Comment to planning proposal ref: PO/12/21/L

30 November 2021

From Mr C Richards & Mrs J Prewett

We reside at Slate Cottage, the property immediately adjacent (north west) of the proposal site, St John's Cottage.

GARAGE
WEST ELEVATION *IN ISOLATION* 1:50

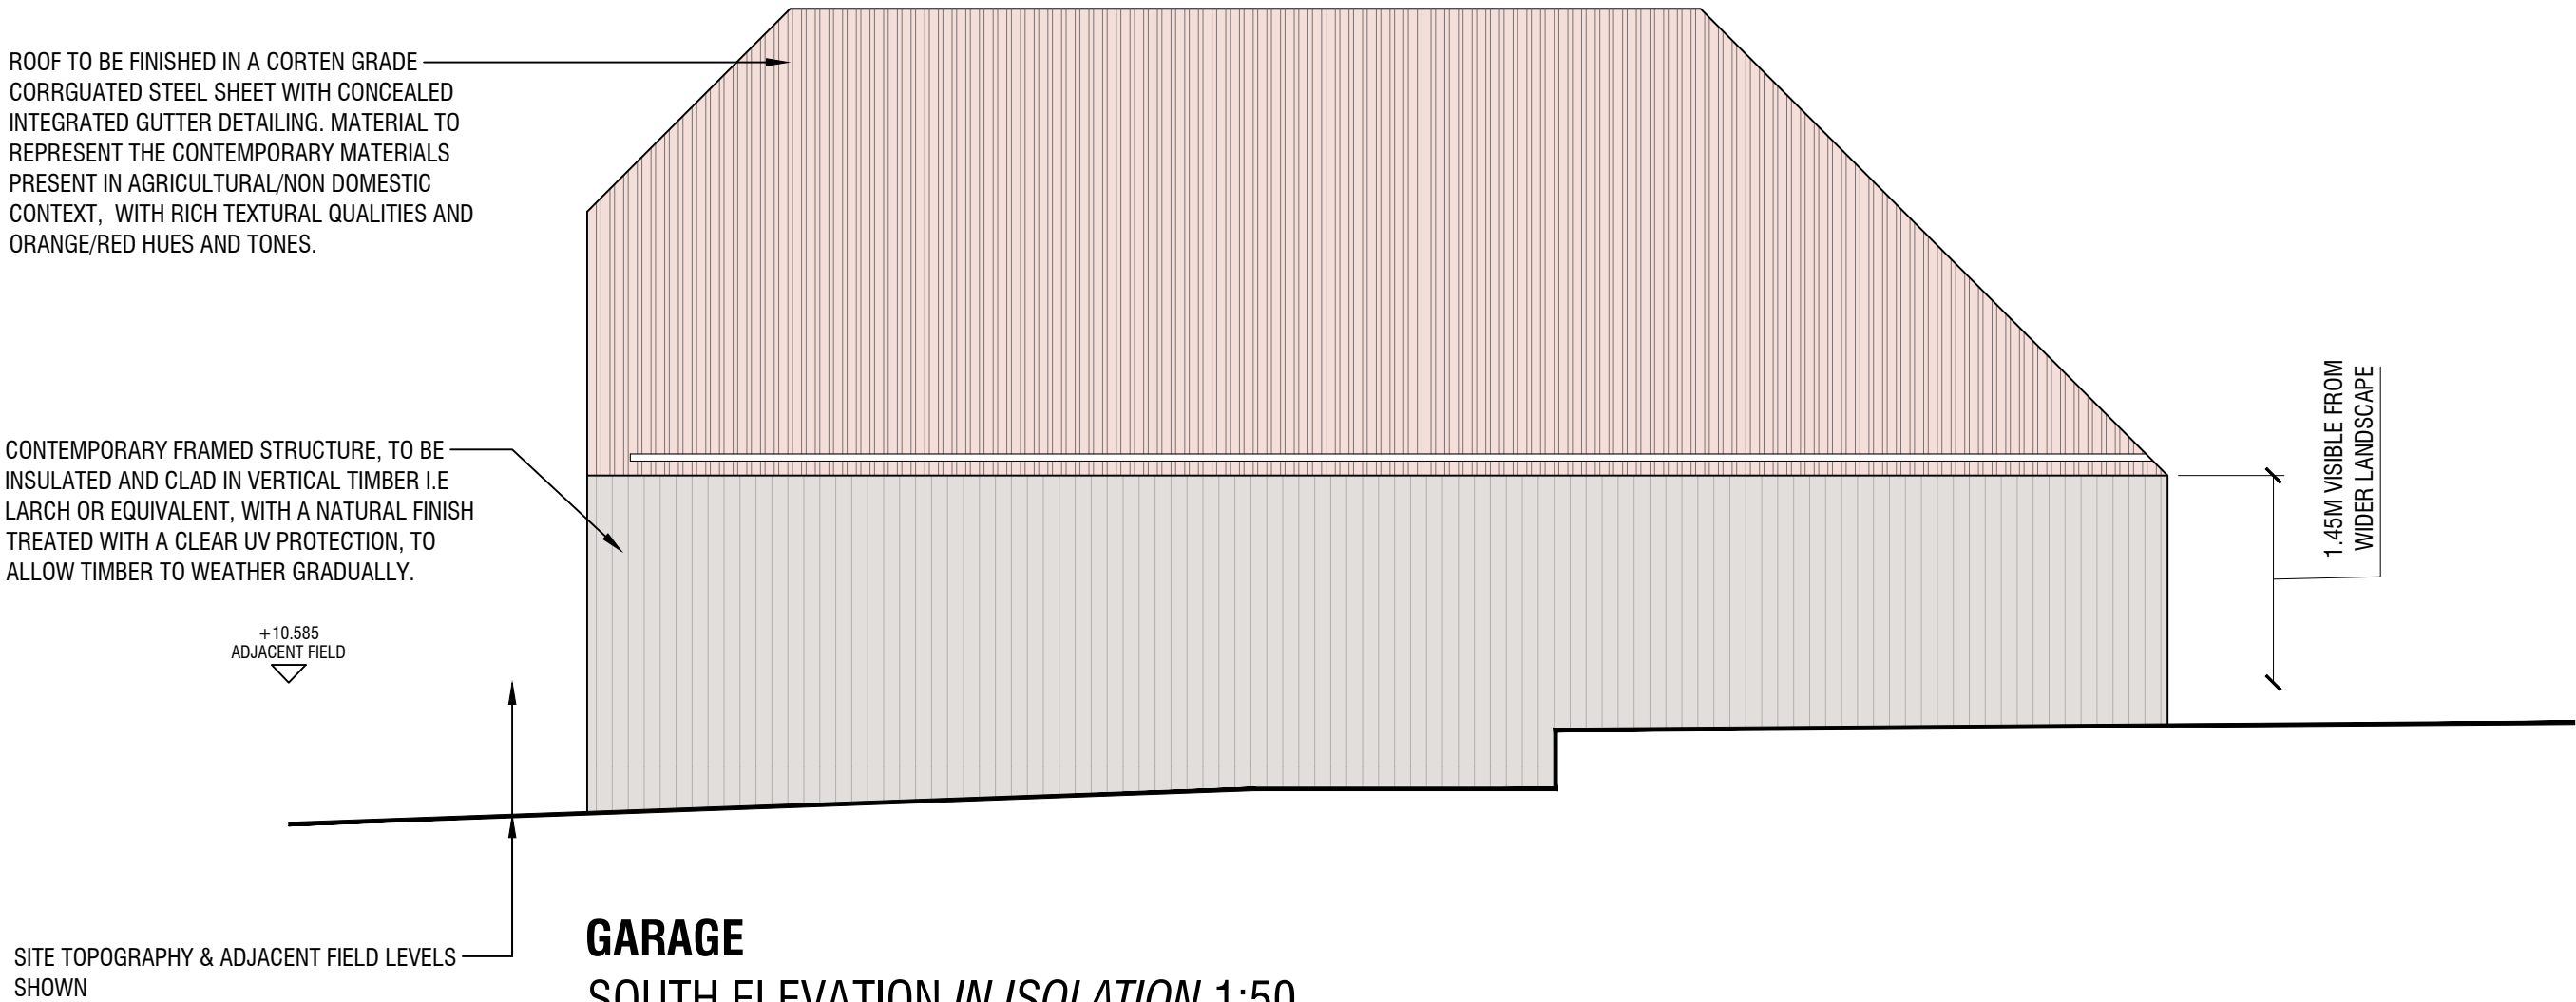
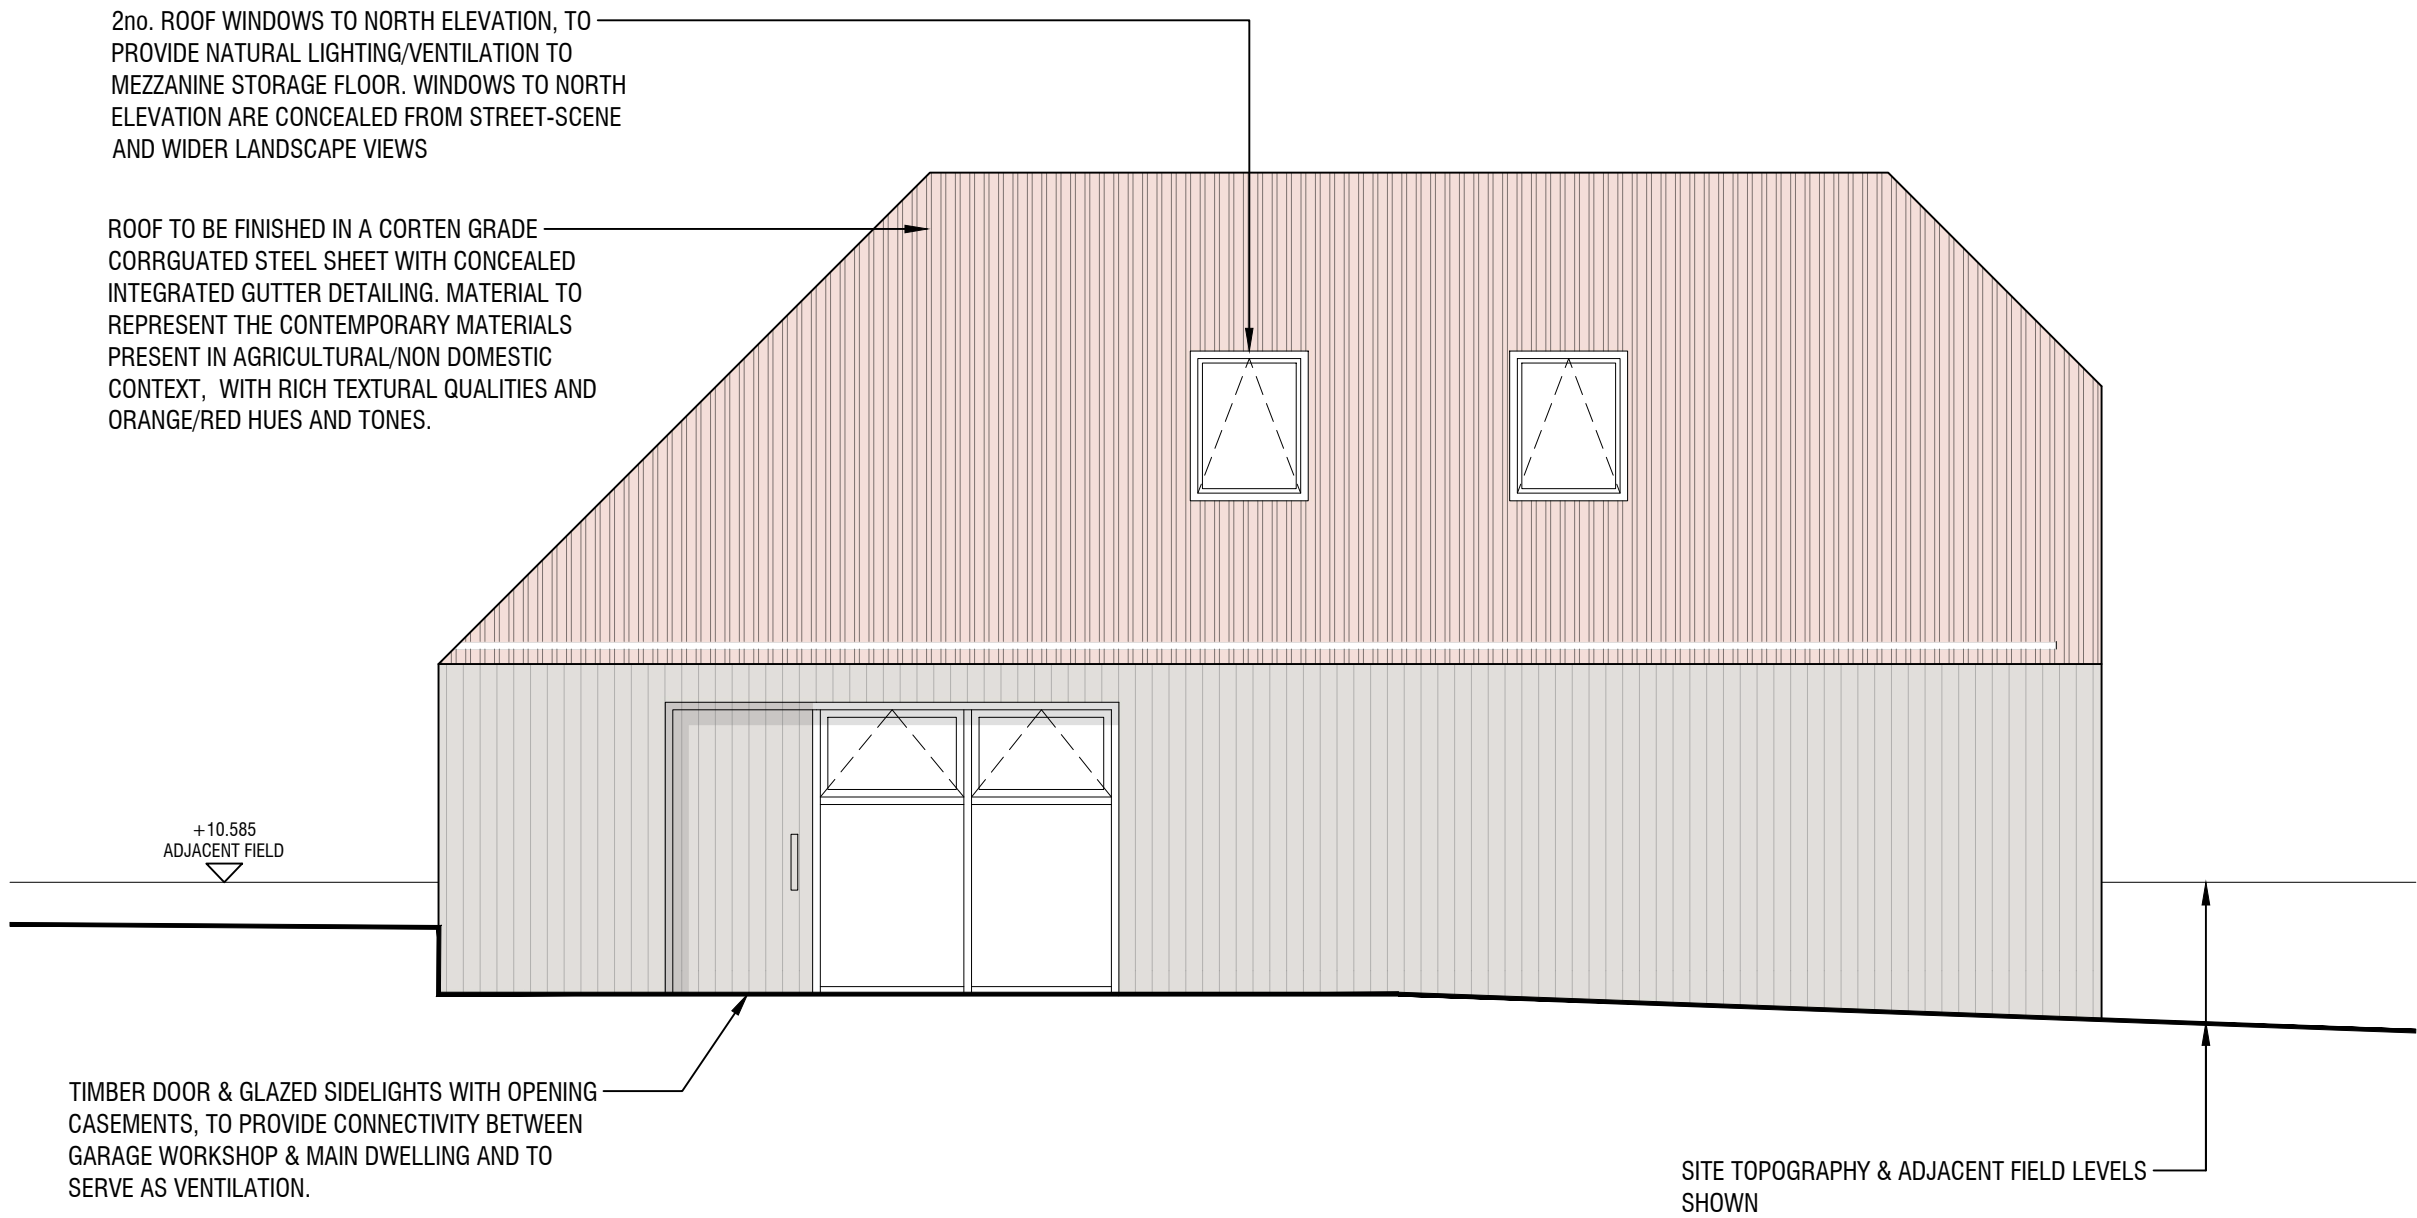
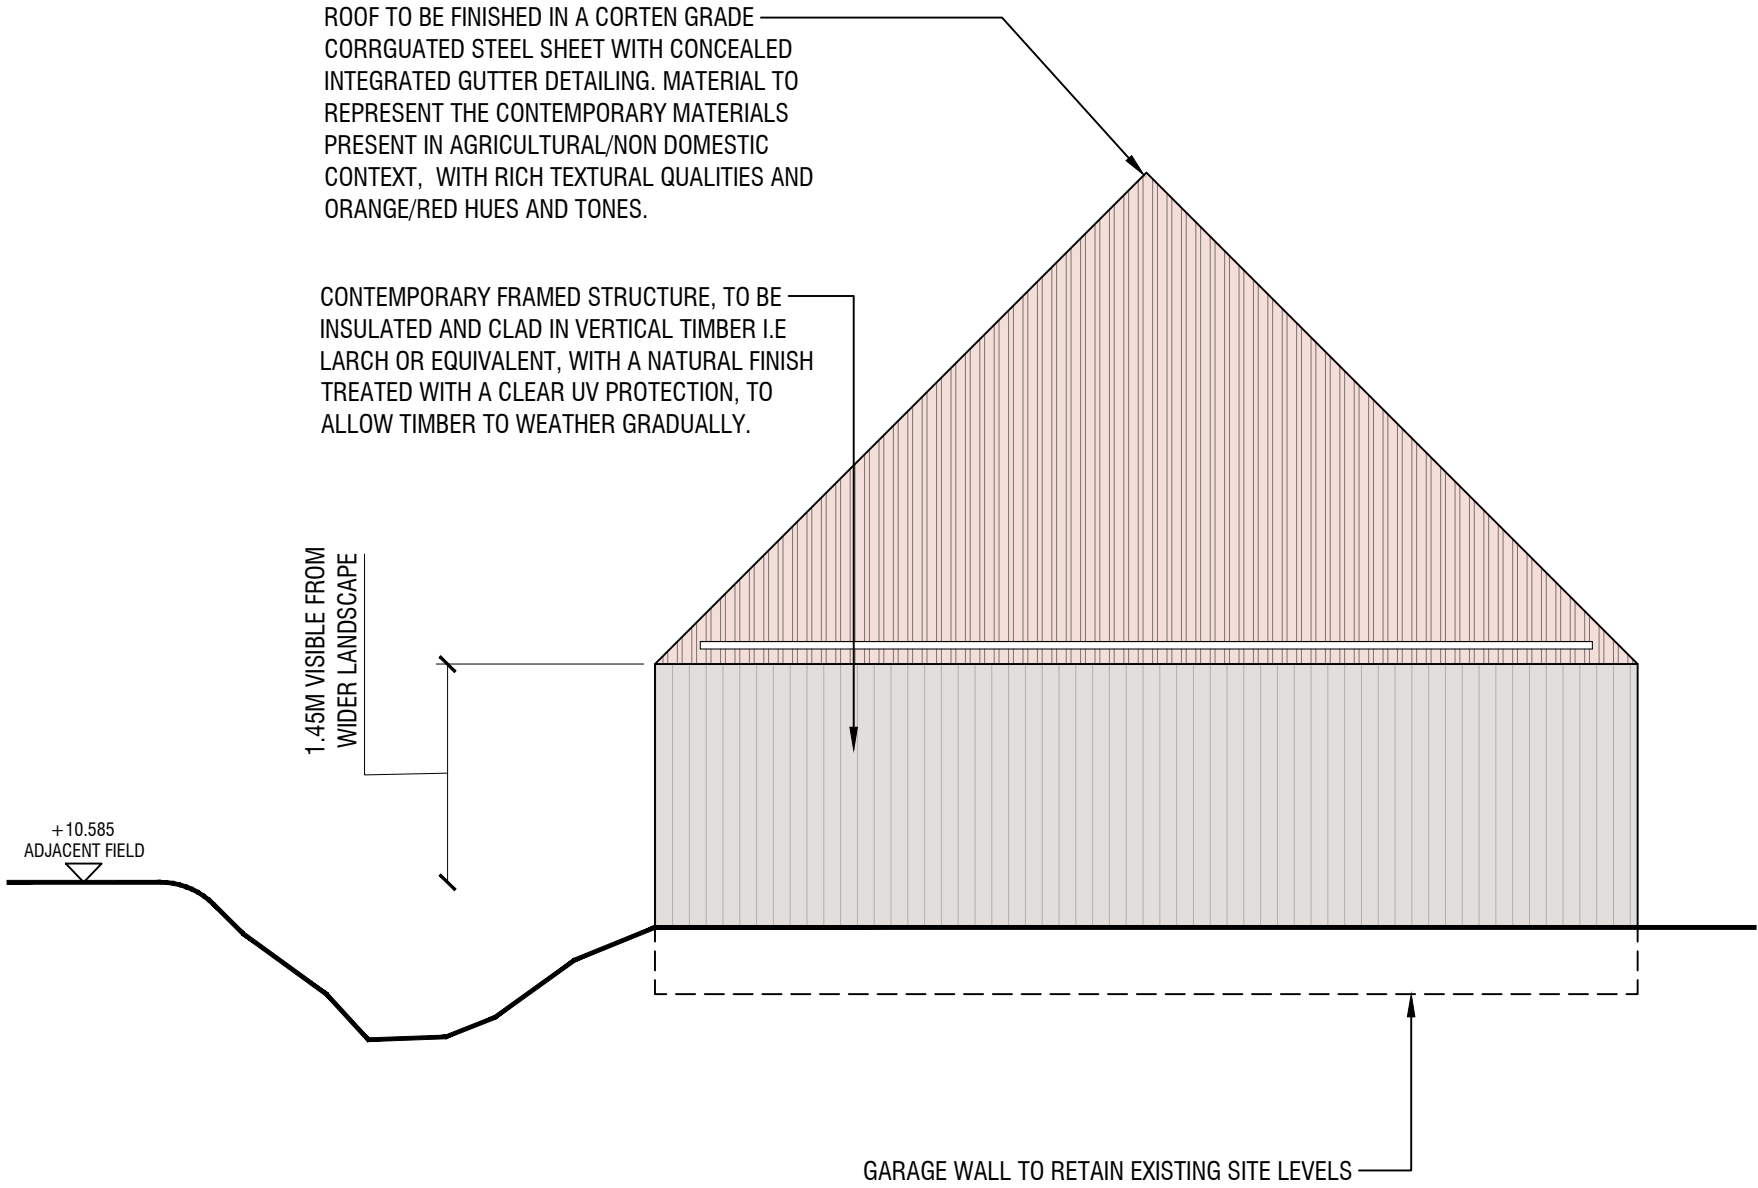
For these reasons it is difficult to see how the proposed mass of both the Garage building and the side/rear extension can be viewed as subservient to the existing Heritage Asset.
